Recommendation Report for Planning Permission for Works or Extension to a Dwelling

REF NO: AW/134/22/HH

LOCATION: 40 Barrack Lane
Aldwick
PO21 4DB

PROPOSAL: Erection of part two storey, part single storey side extension, detached garage with side store and replacement front porch.

Title
First Floor
Plans as Proposed

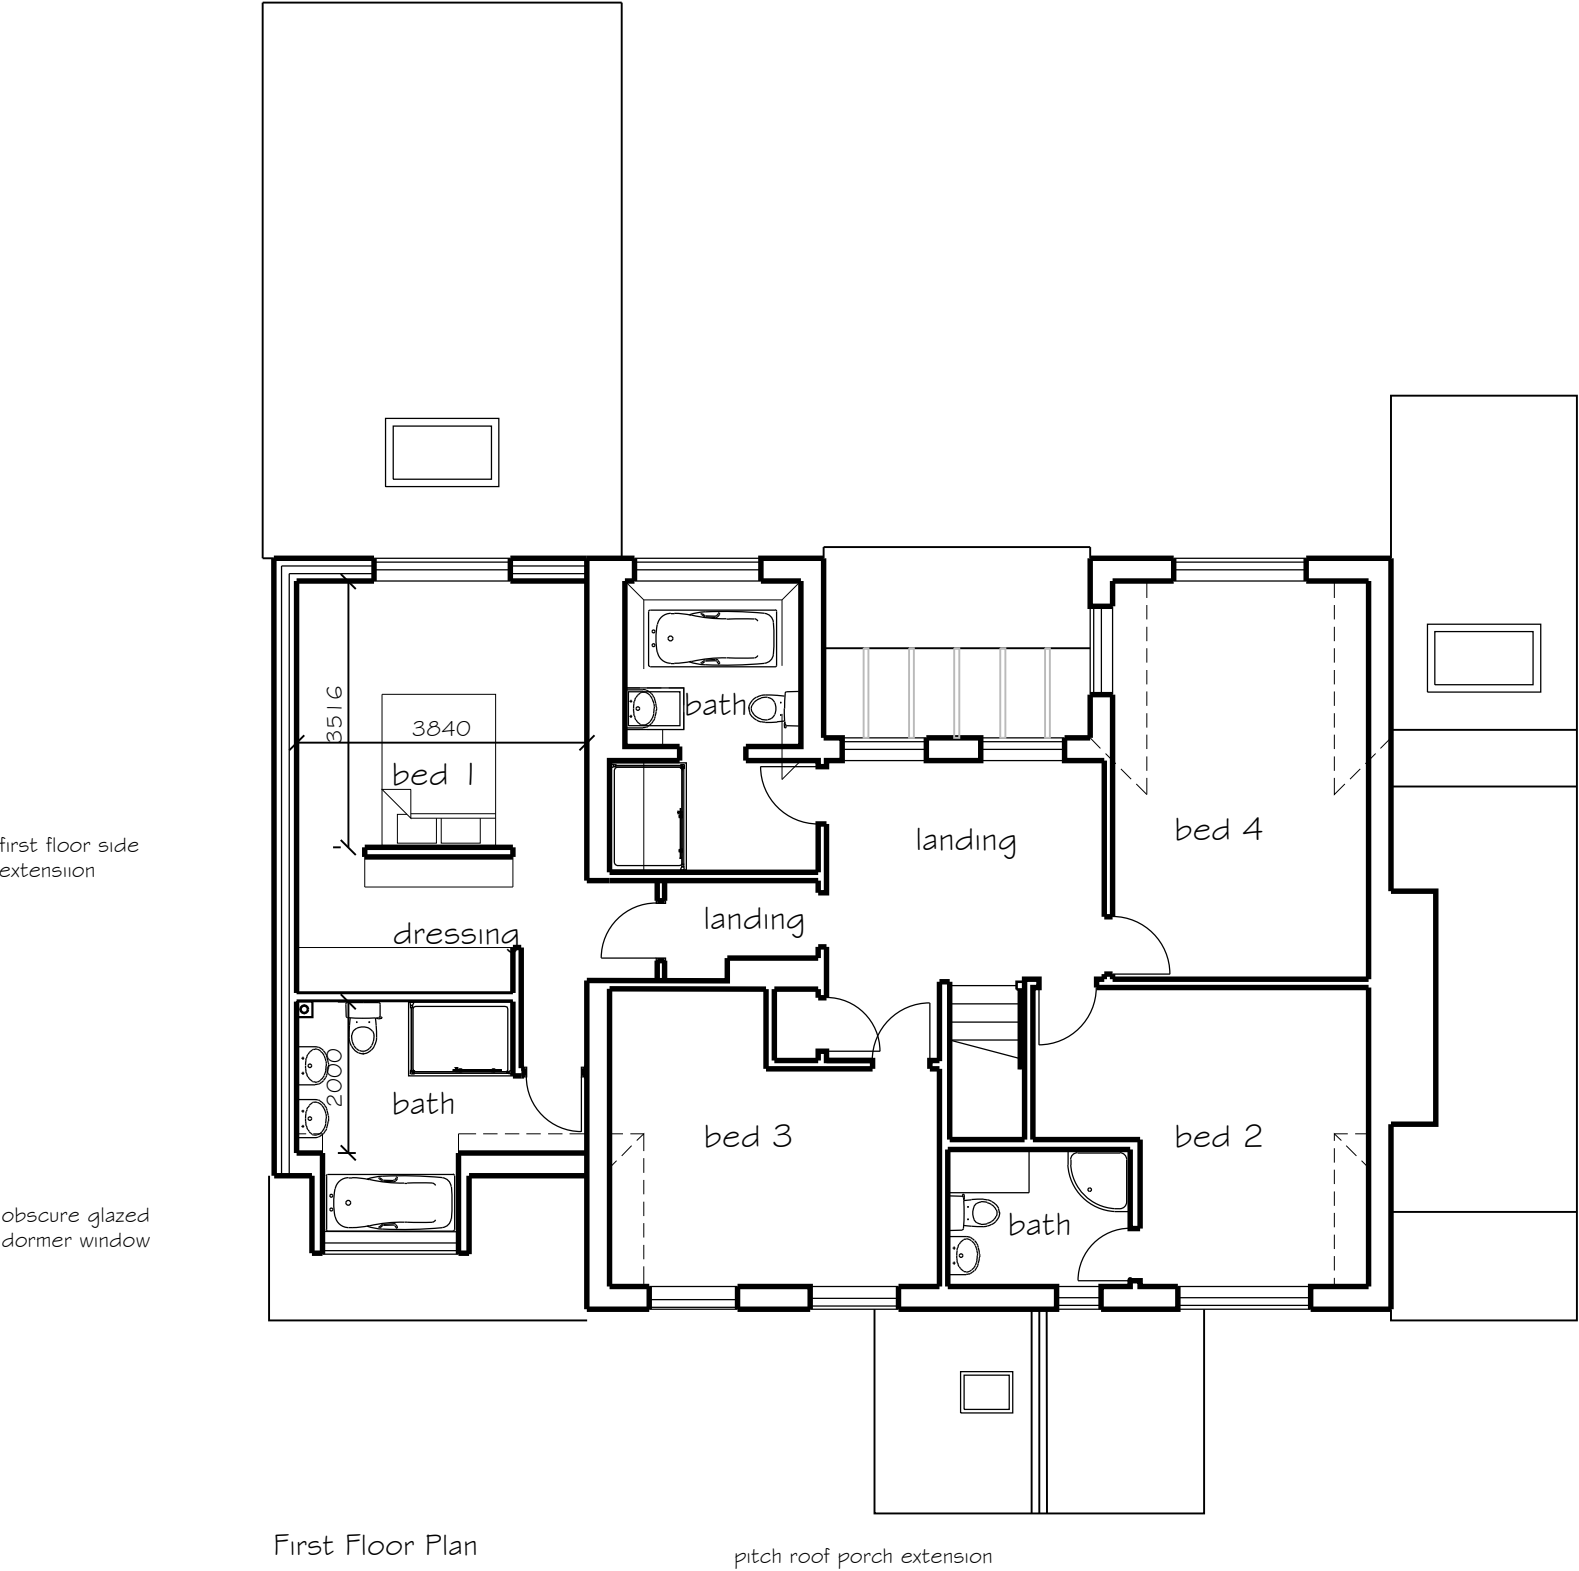
The extension will have a width of around 4.2m, situated above an existing ground floor addition and run the full length of the property meeting with the rear. The first-floor side extension will not result in adverse overbearing or overshadowing with no windows to the side elevation of the neighbouring property. The first-floor addition does not appear to extend beyond the rear two storey building line of No.42.

There are no first-floor side facing windows to the extension, although there will be additional front and rear facing window. The rear facing window will provide some additional views over the neighbouring garden when looking at a 45-degree angle although these are not direct into windows and are similar to that which are already achievable. The front facing window will have views over the large front garden and street scene.

Title
Garage + Side Store
Plans + Elevations

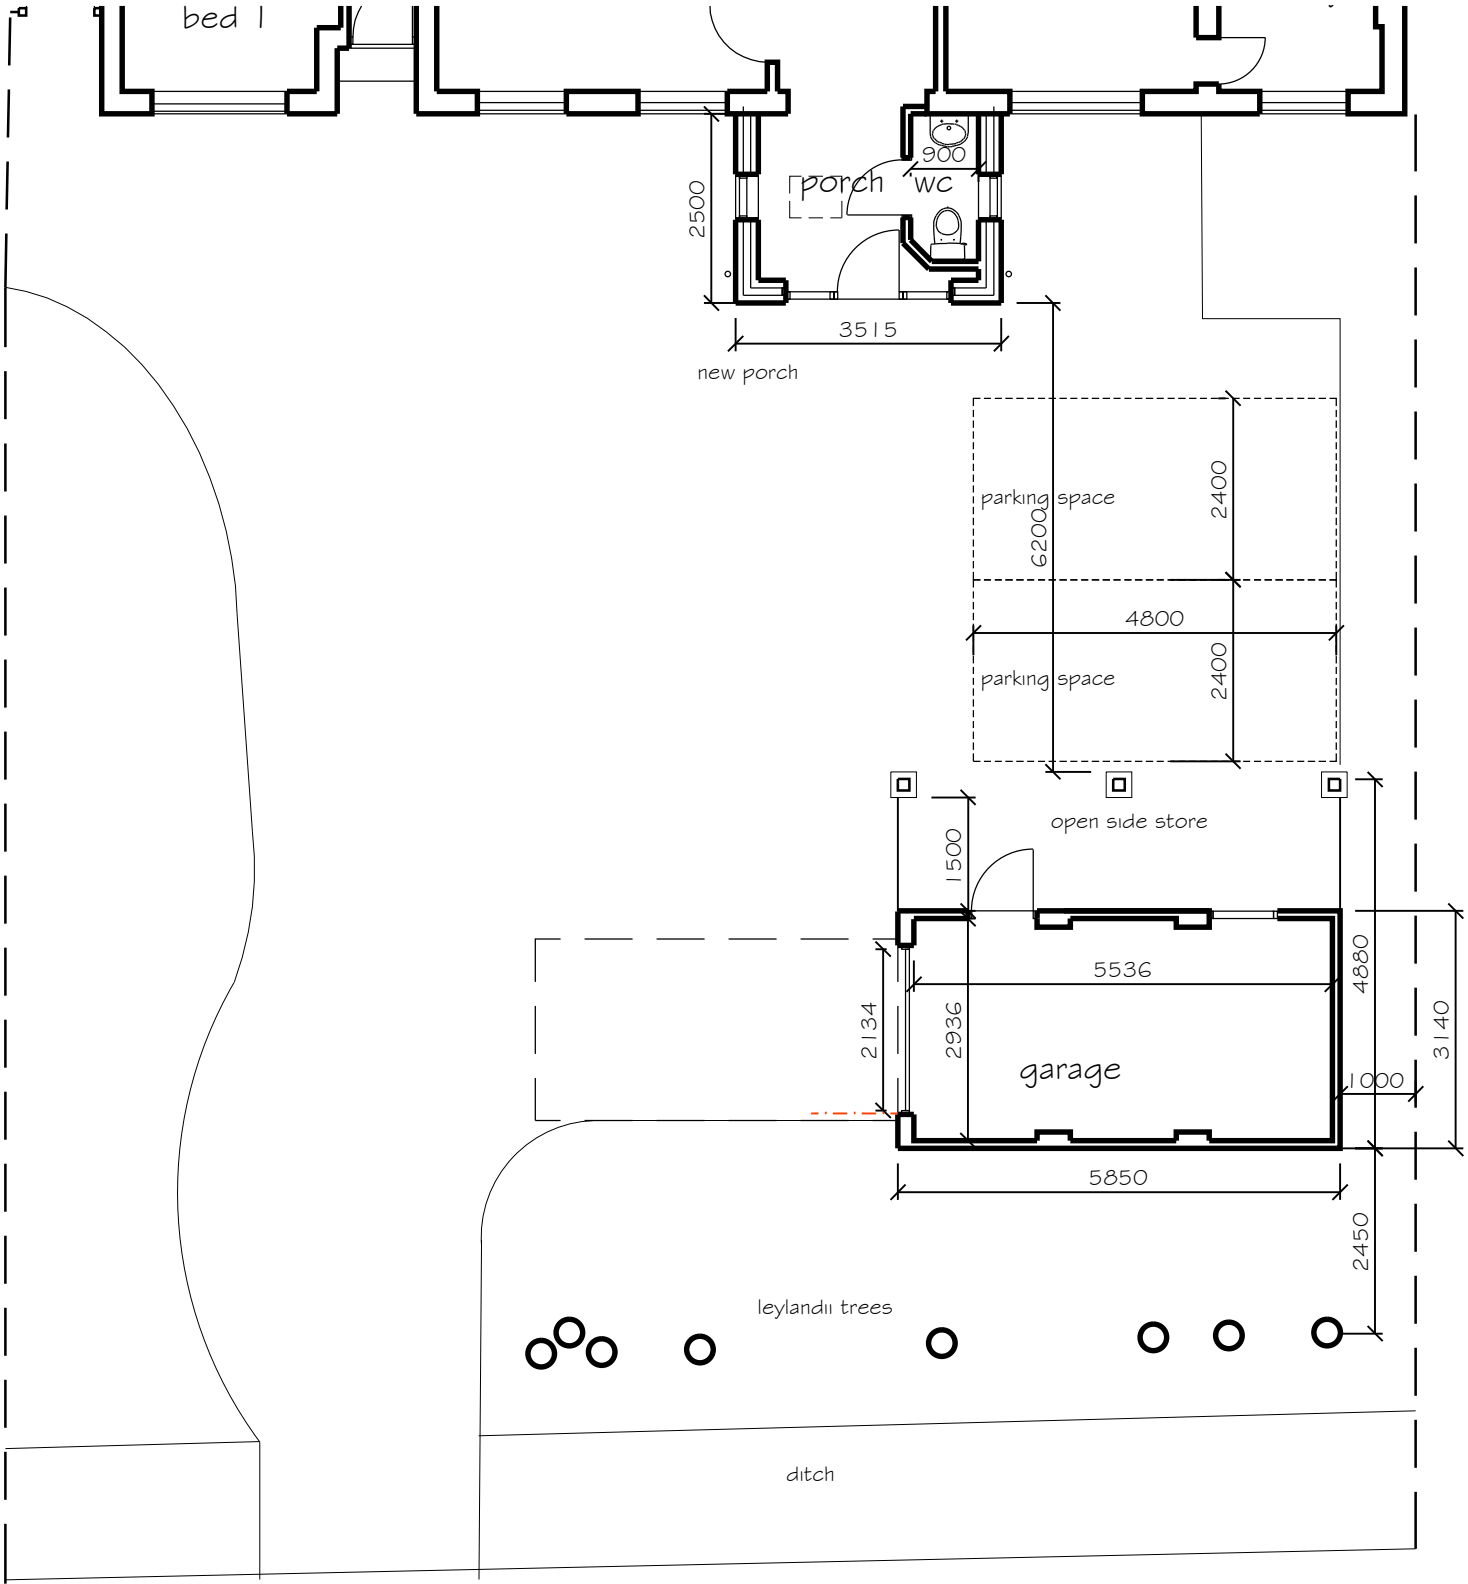
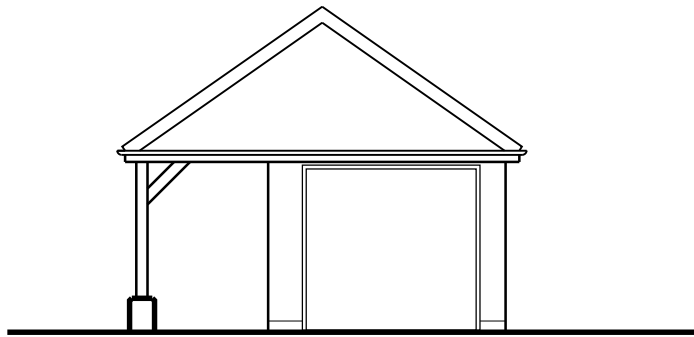
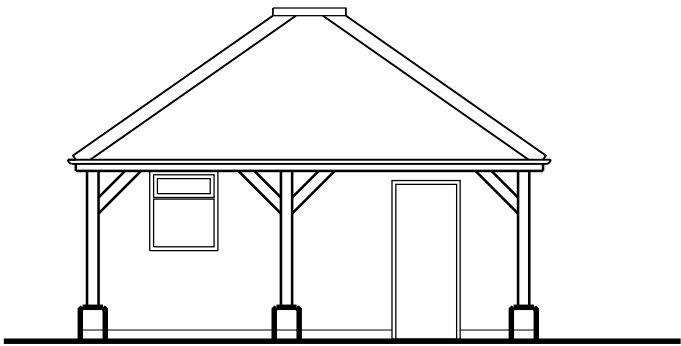
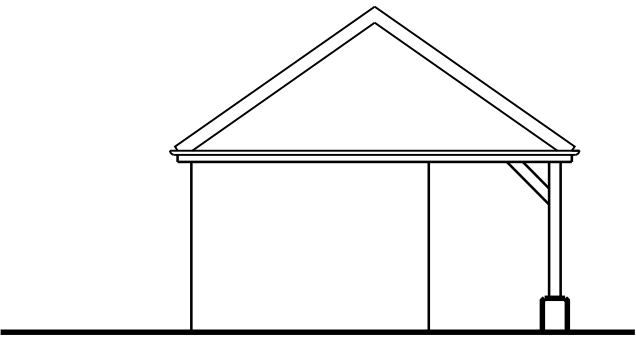
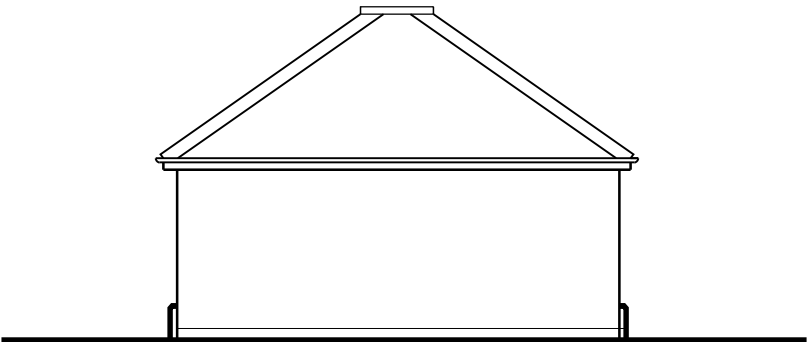
A detached garage is proposed which will feature an open canopy area to serve as a side store. This will be to the front southeast corner of the site set back around 2.5m from the front boundary. This is slightly out of character although there is one other example of a garage sited in a similar position to No.36 and as such its location to the front boundary does not warrant refusal. There is tree planting along the boundary which restricts much of the view.

The garage will have a maximum height of 4.4m with eaves to 2.35m. This retains 1m to the north-eastern boundary. As a result of the roof design, which is hipped and therefore slopes away from the boundary, and due to its location, set forward away from the front facing windows at No.38, it will not result in adverse harm. There is planting along the boundary to help screen views.

Title
South East + South West Elevation
Plans as Proposed

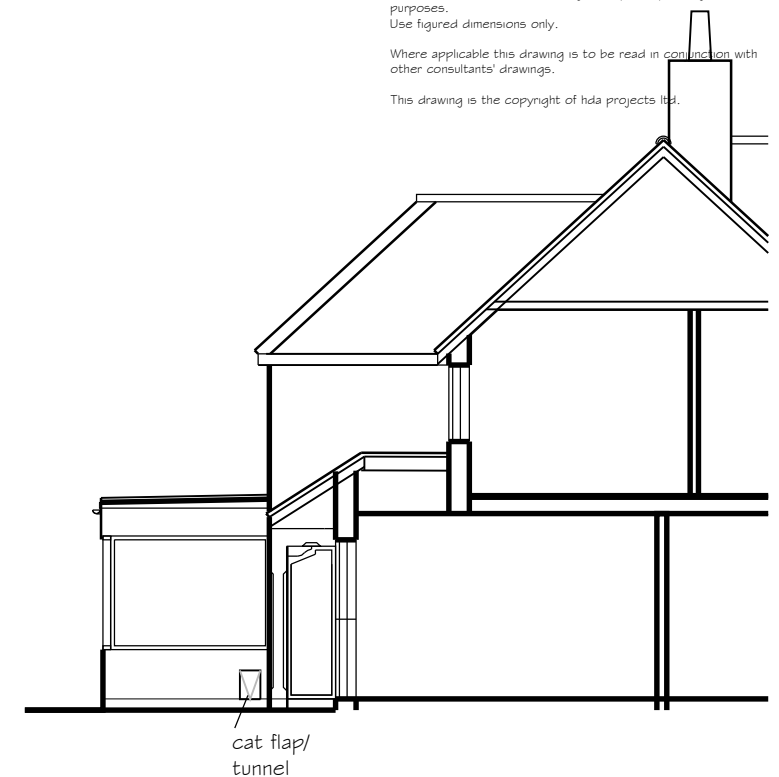
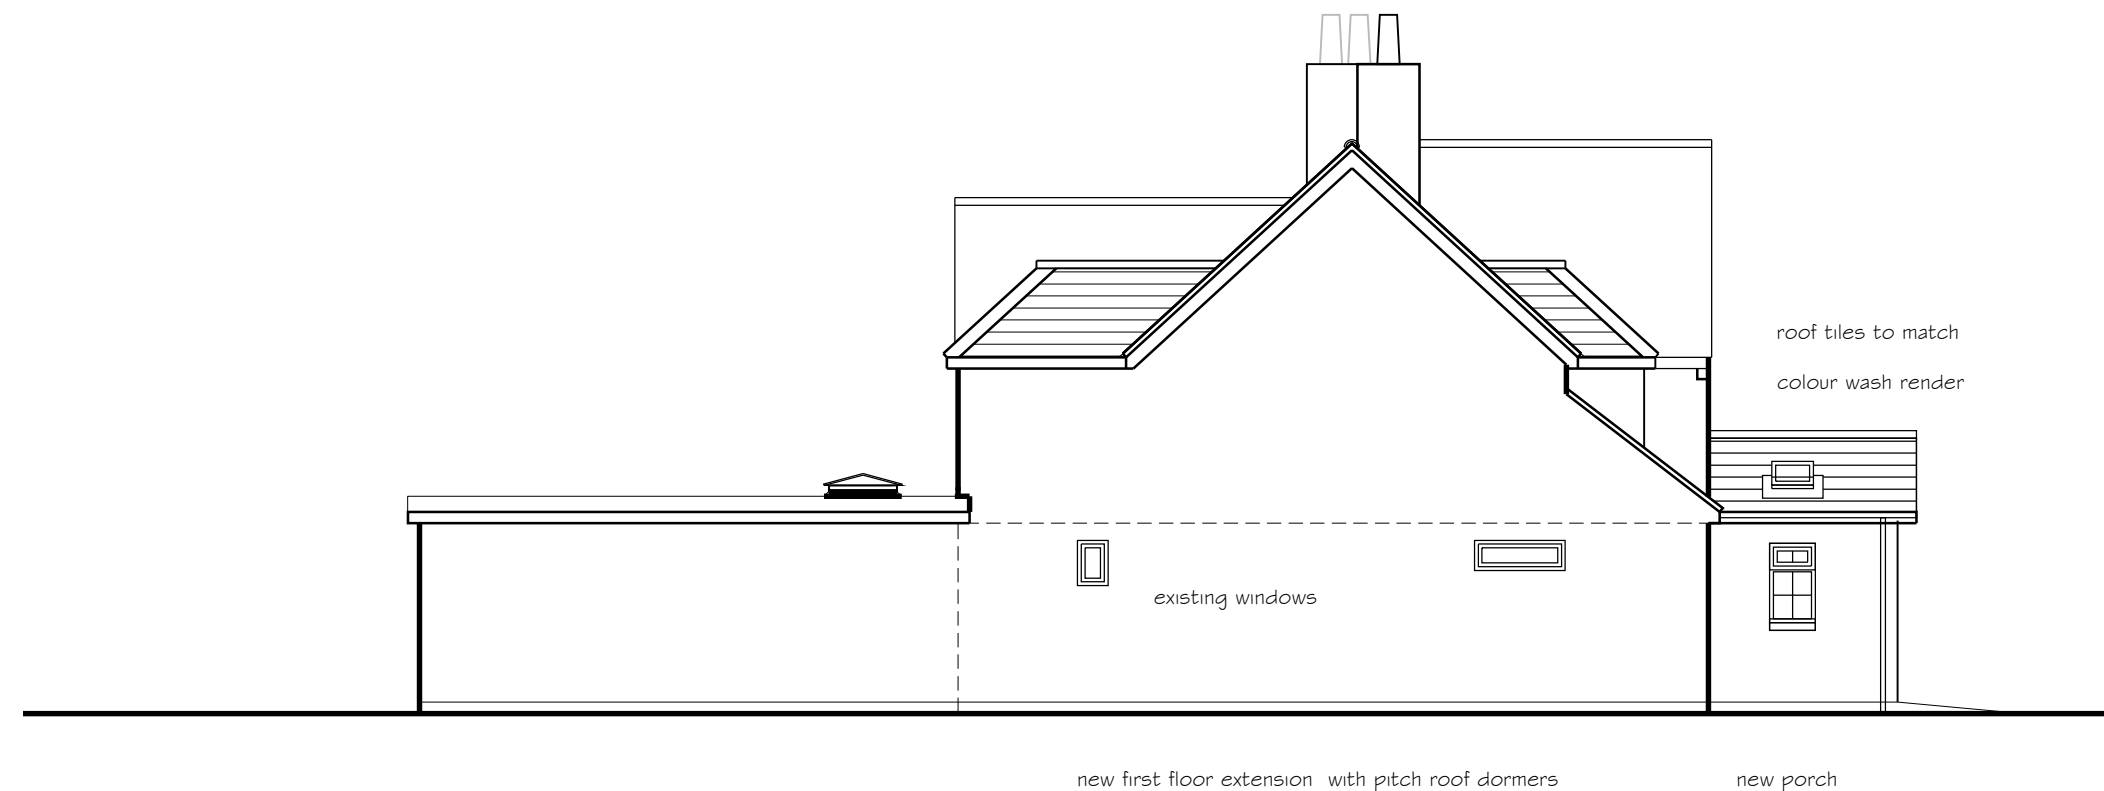
This is well integrated with the dwelling. The roof extends in line with the ridge of the main dwelling and features a pitched dormer to the front and rear which is sympathetic in design to the main property. Materials will consist of colourwash render to match that host dwelling.

A porch is proposed and will replace an existing one although the depth will increase to 2.5m. It adds some bulk to the front with a width of 3.5m although does not extend forward of the established development line.

Title
North East+North West Elevations

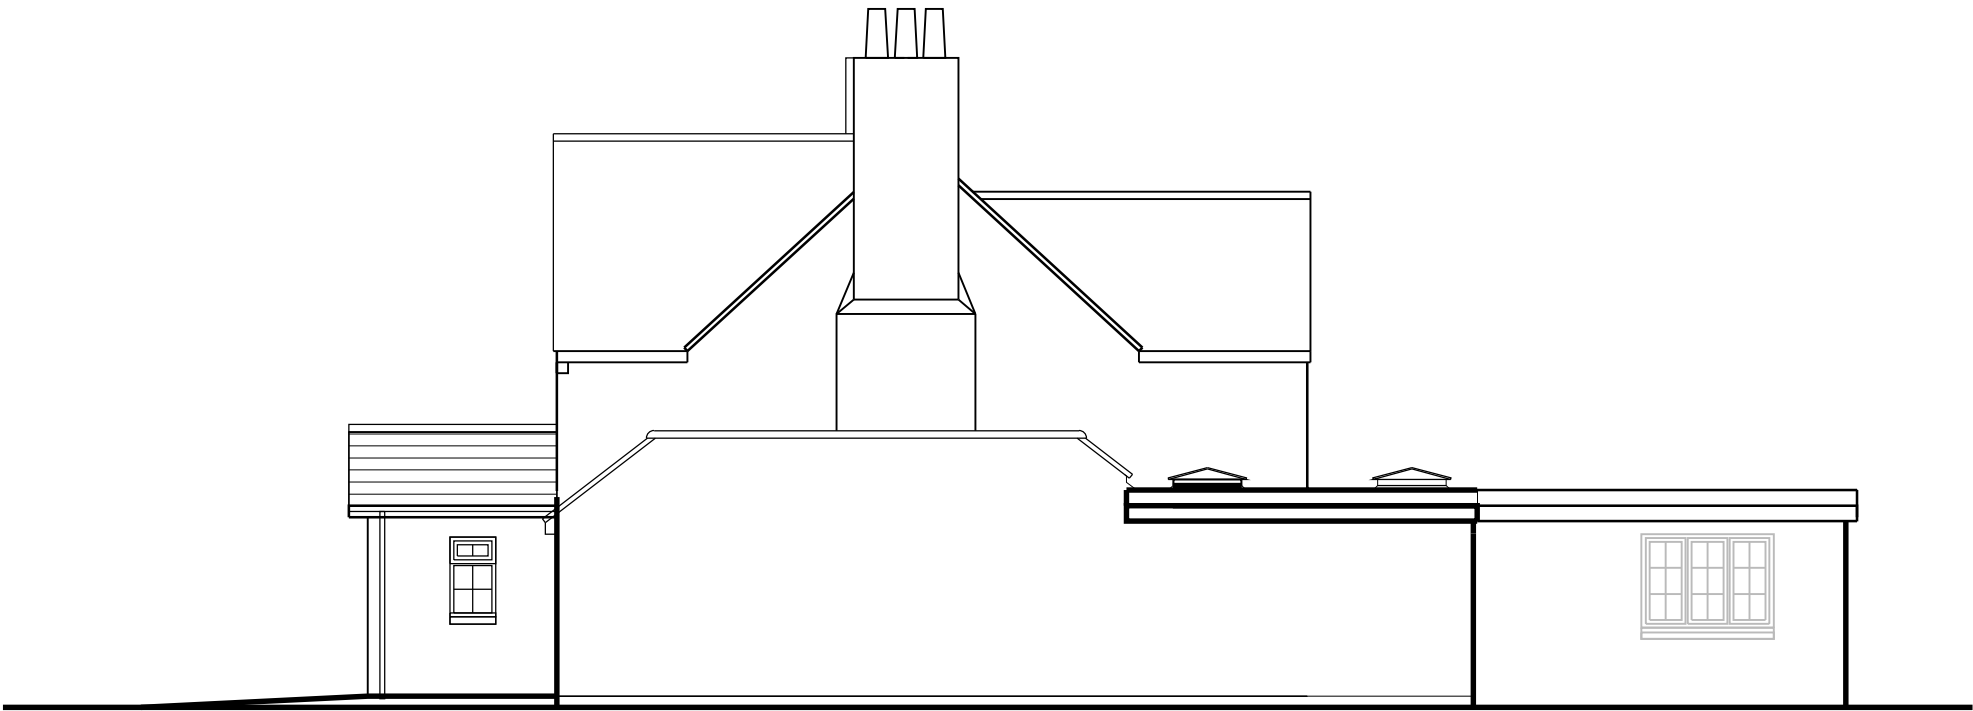
The proposal complies in part with the guide. The side extension is not set down below the ridge line which reduces its subservience to the host dwelling. It does not retain 2m at first floor level to the boundary although with space retained to the neighbouring side, it does not result in a terracing effect. The extension does however respond to the existing character and appearance of the building, with the materials and scale appropriate.
